CITY OF ALBUQUERQUE

February 7, 2022

**RE: Saranam Golf Course & Montano
4701 Montano Rd NW
Grading and Drainage Plan
Engineer's Stamp Date: 1/4/2022
Hydrology File: E11D013B**

Based upon the information provided in your submittal received 1/4/2022, the Grading & Drainage Plan is **not** approved for Building Permit. The following comments need to be addressed for approval of the above referenced project:

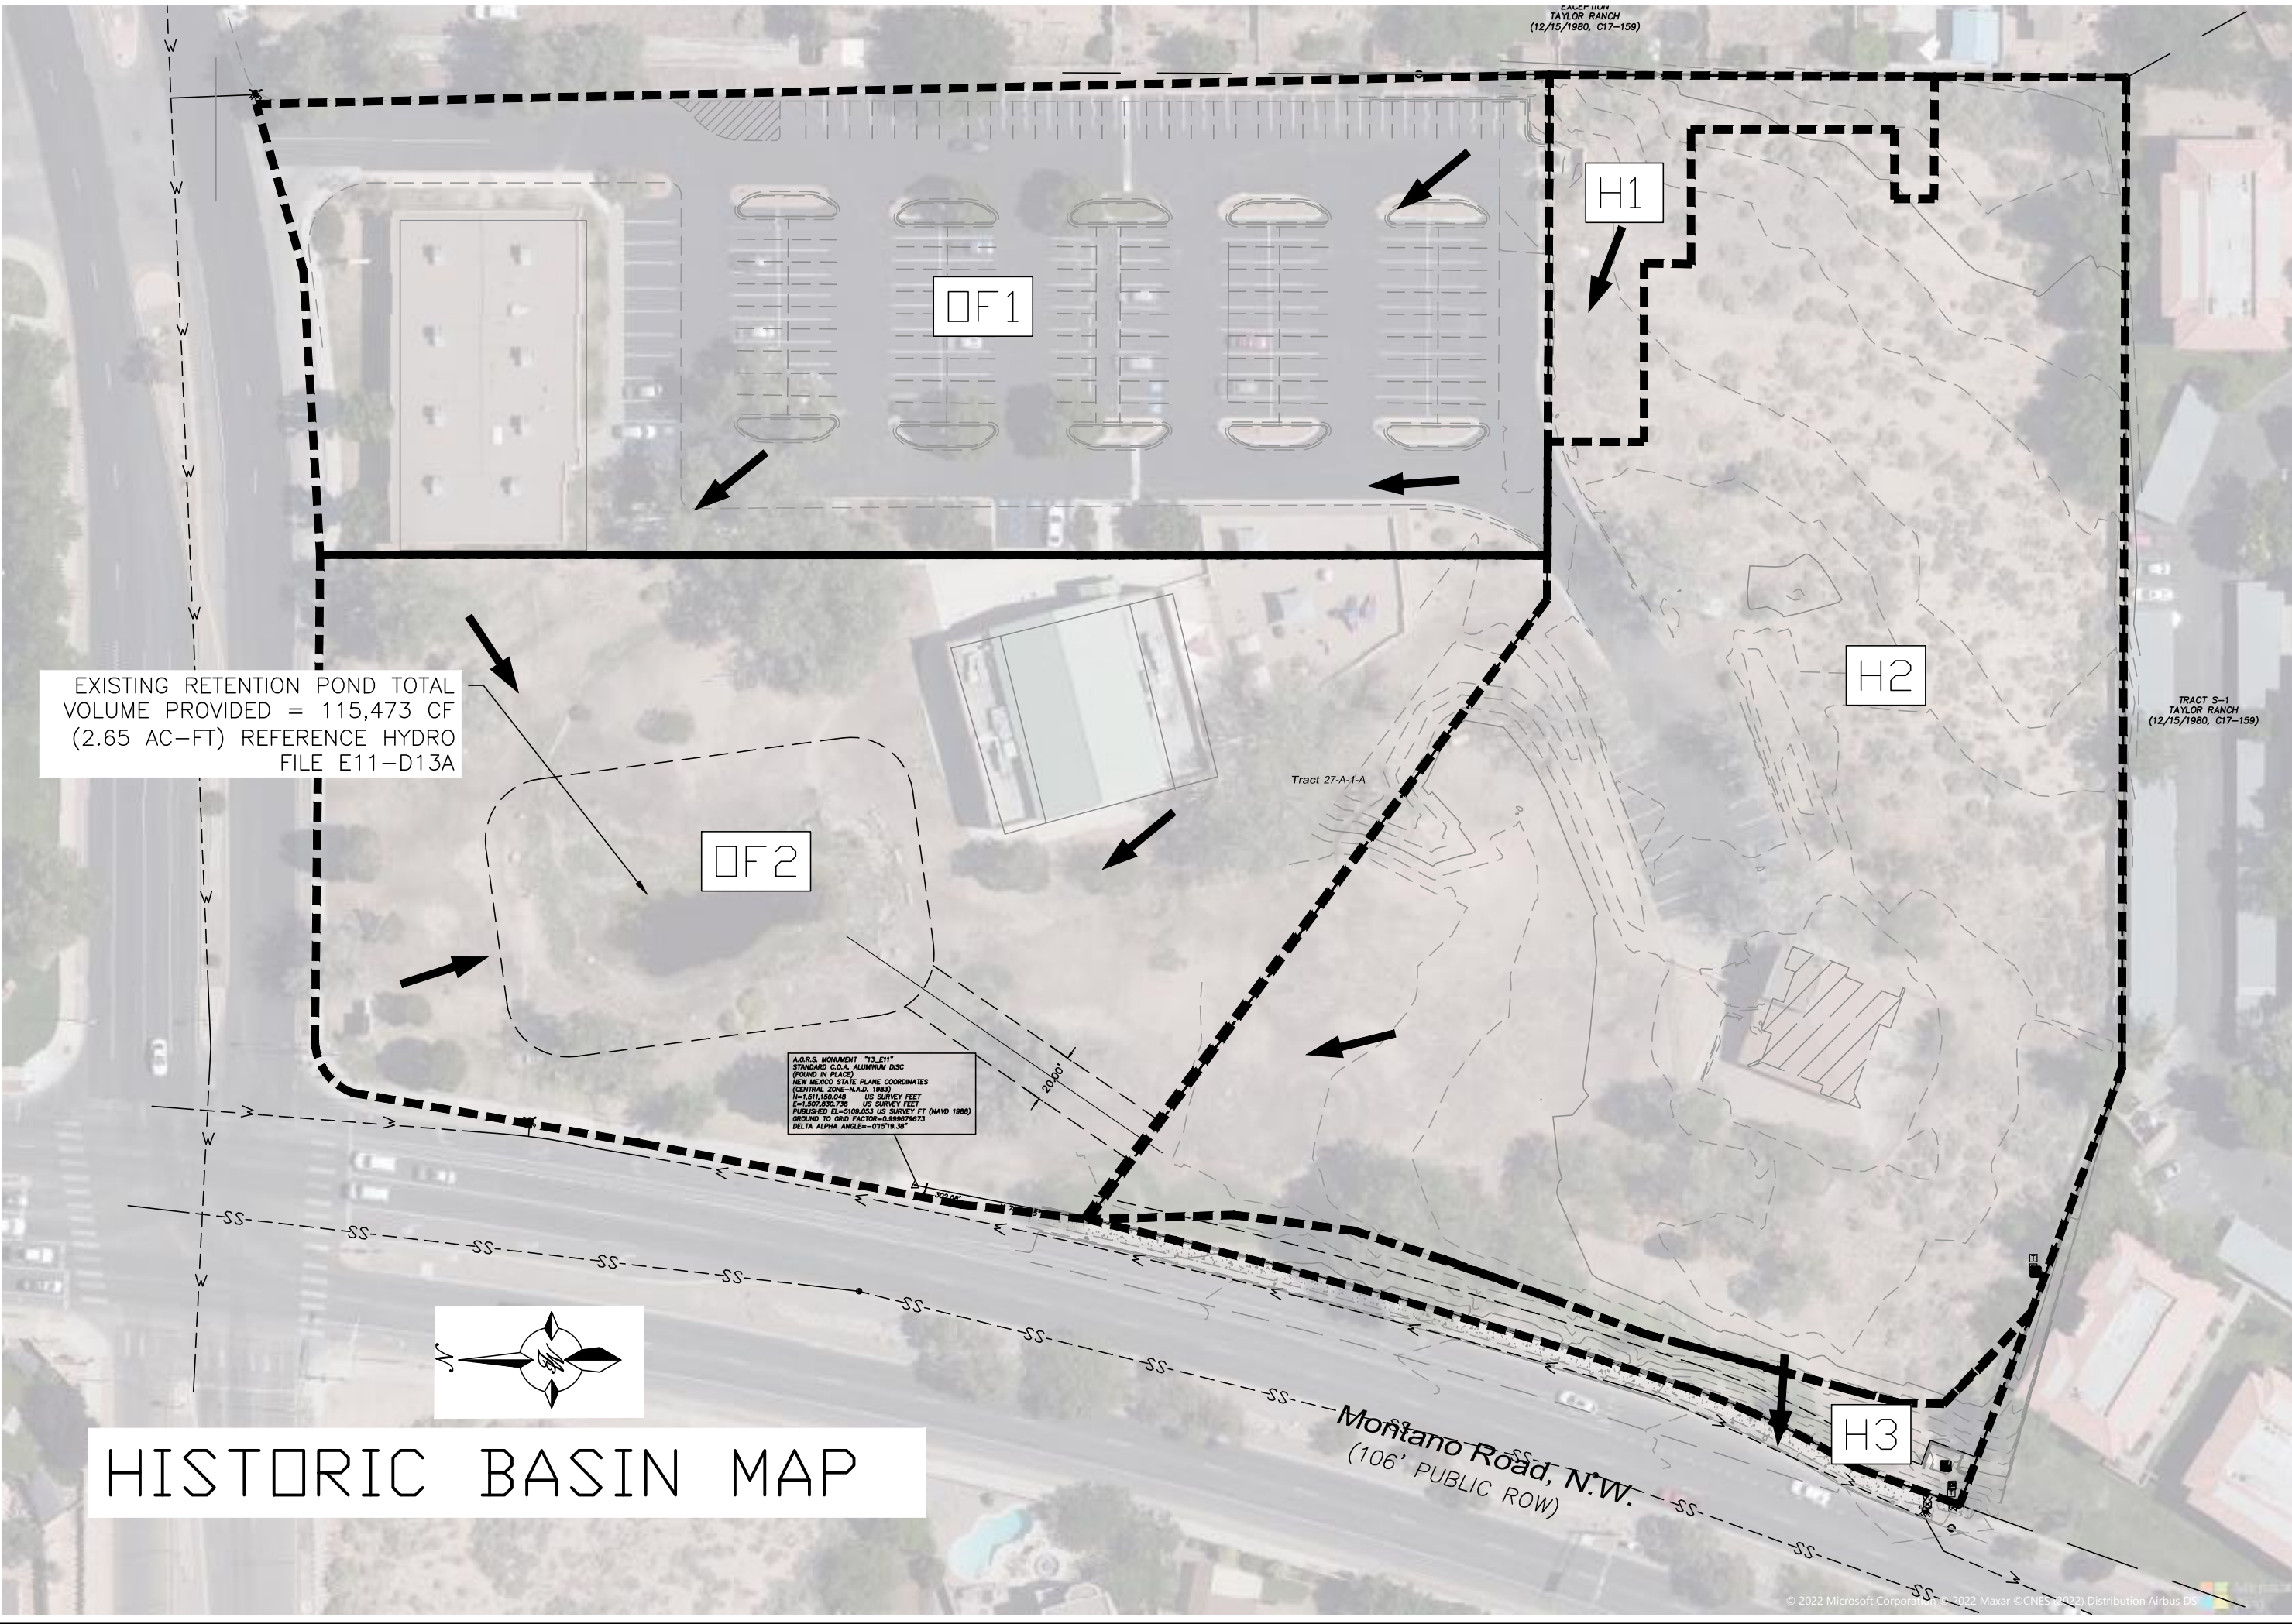
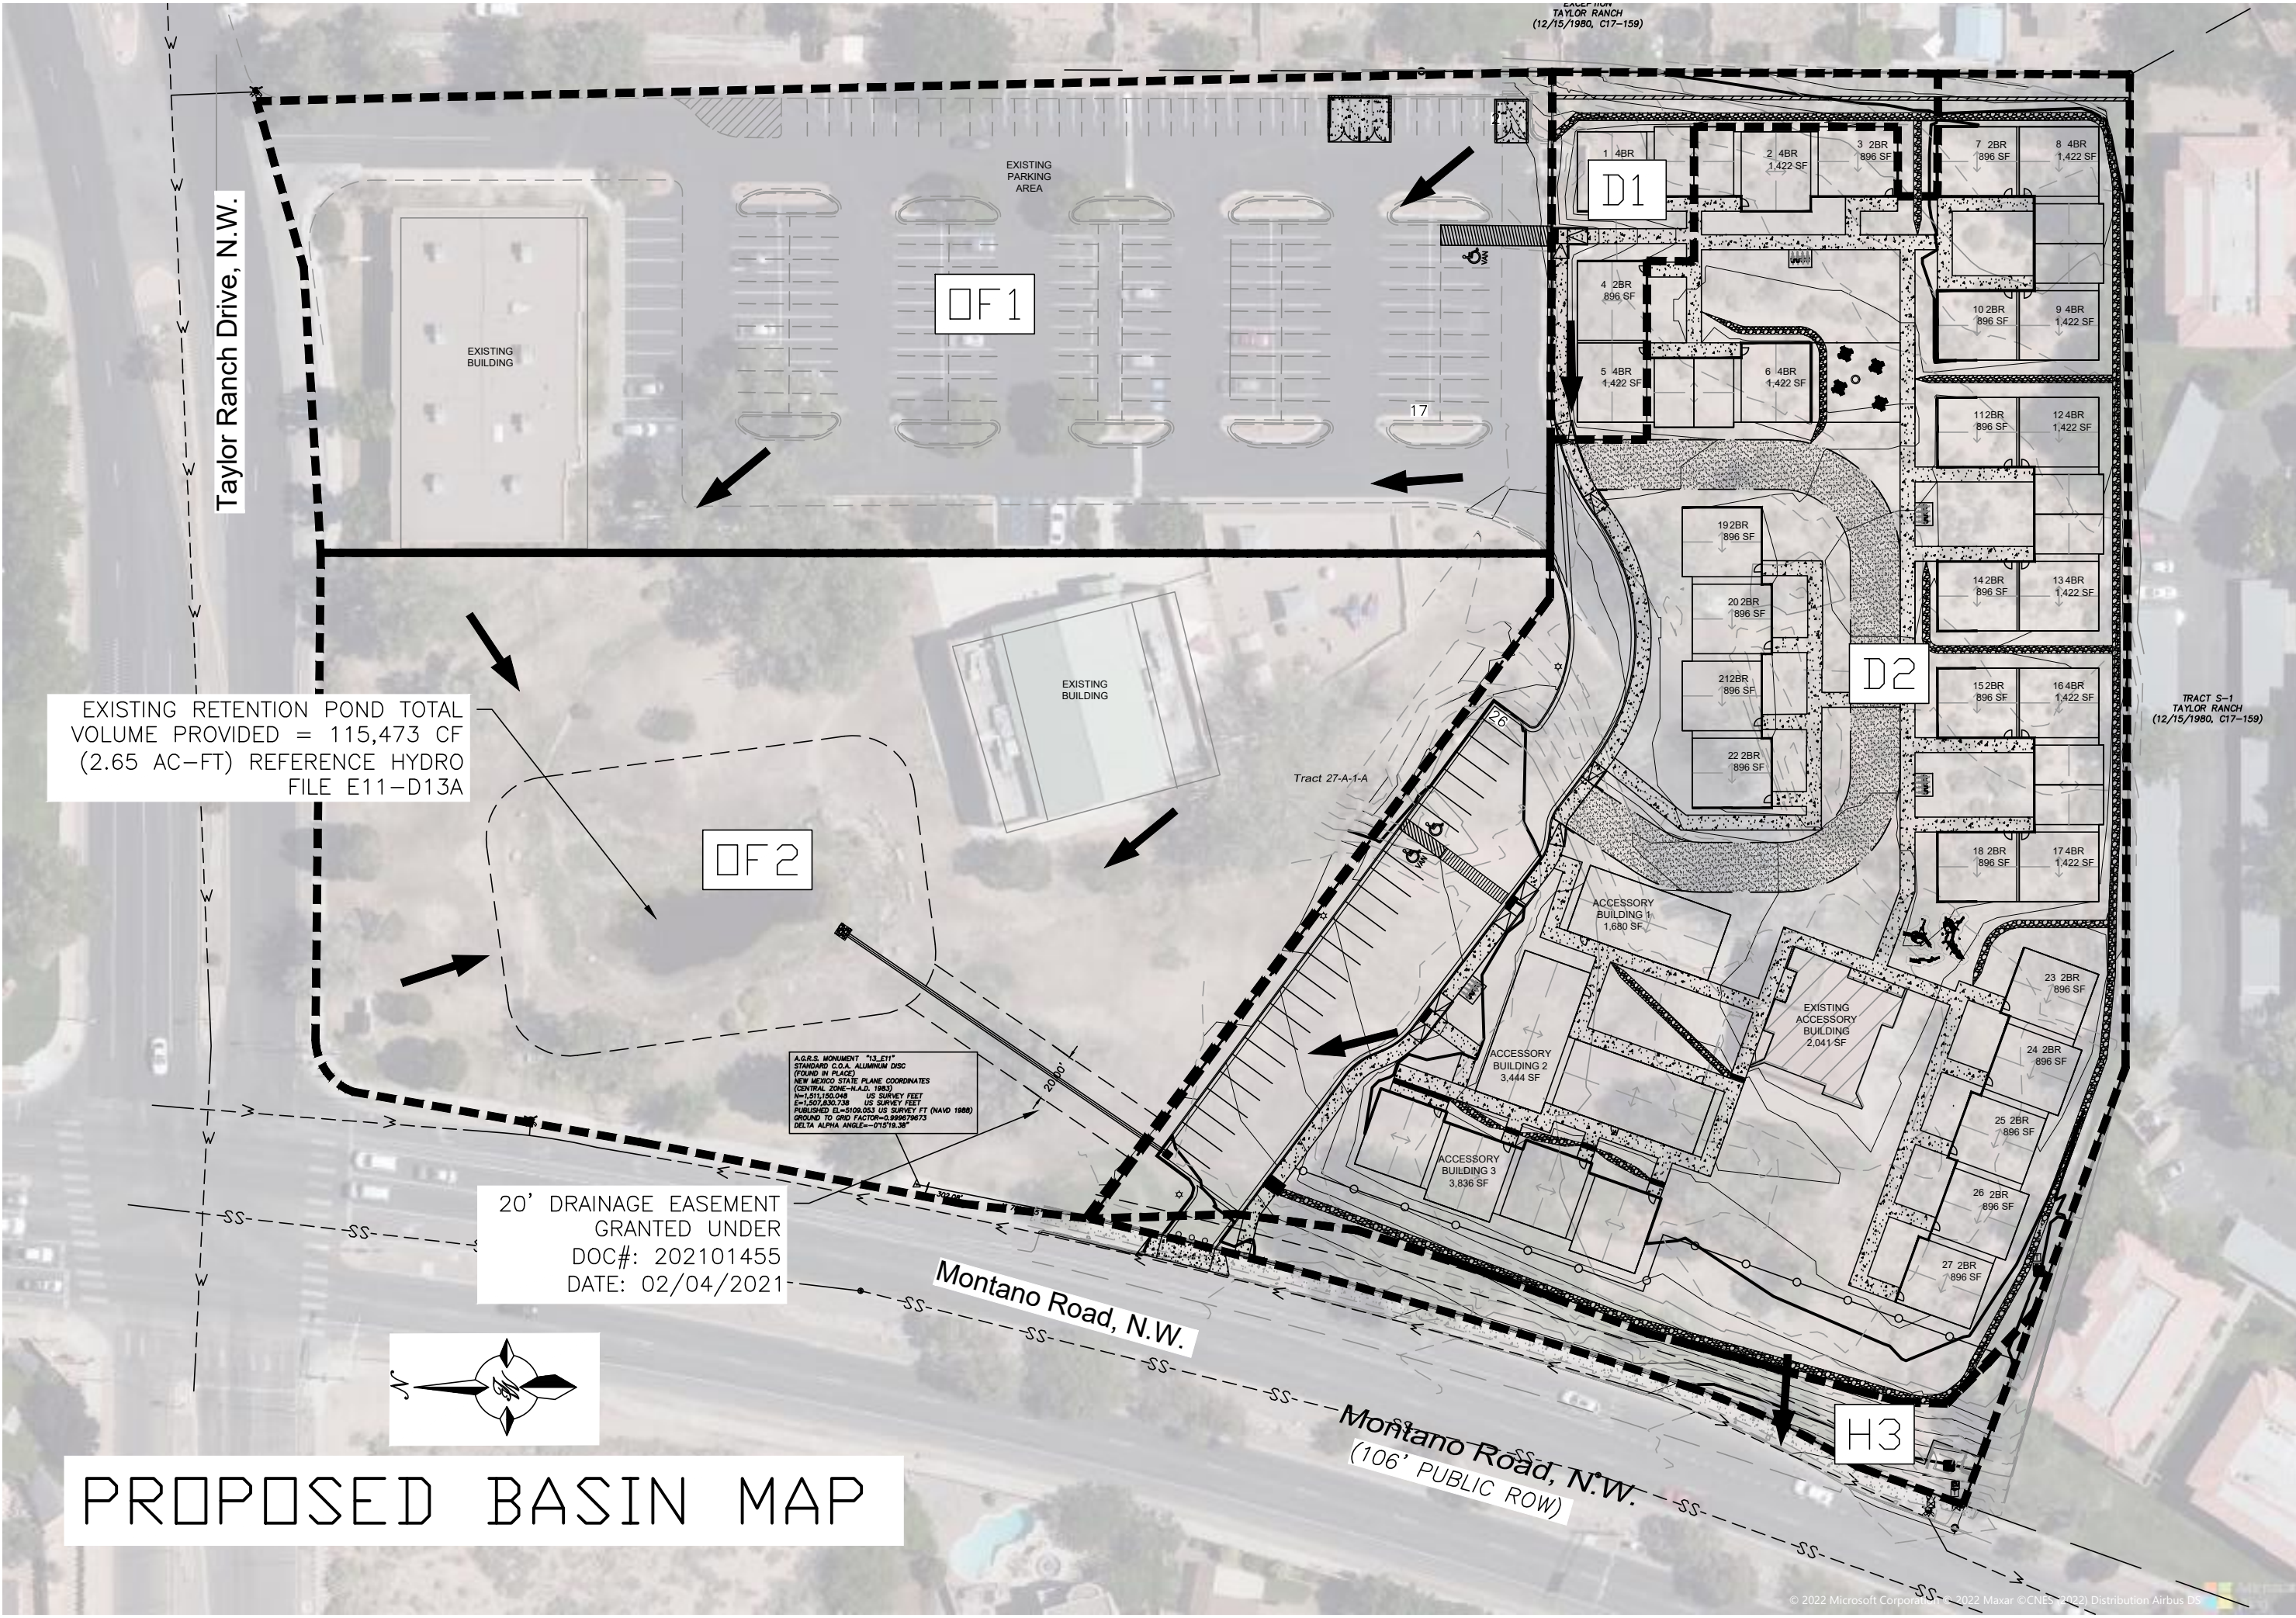
SHEET C2.1

1. Please double check the calculations for the tables provided. I checked a couple and did not come up with the same.
2. Please include the required volume for retention. (100-year, 10-day storm)
